CITY OF ALBUQUERQUE

February 10, 2017

Re: McMahon Market Place New Shell Building
5708 McMahon Blvd. NW
Request for Temporary 30-Day CO – Accepted
Engineer's Stamp dated: 6-30-16 (A11D001E)
Certification dated: 2-6-17

COVERED SIDEWALK CULVERT

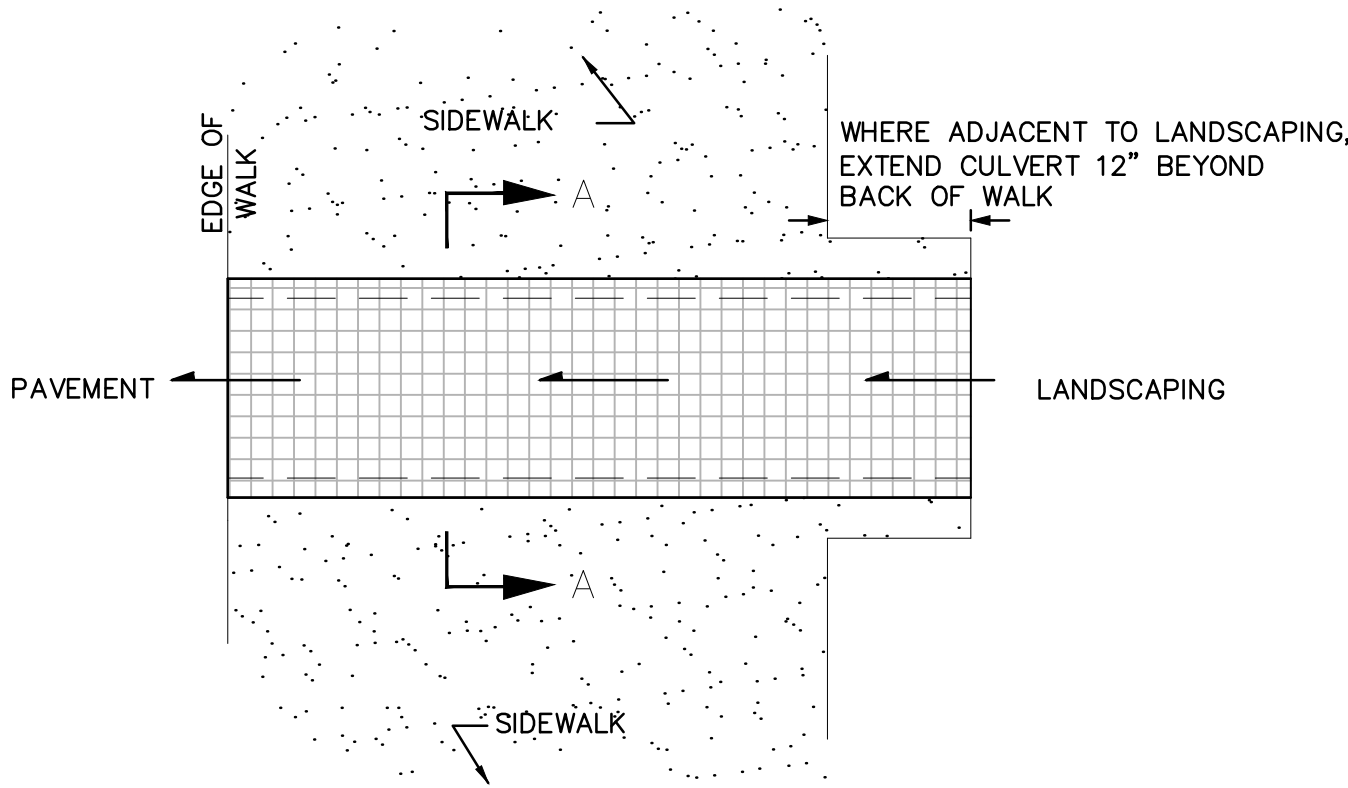
- The sidewalk culvert must be a monolithic pour.
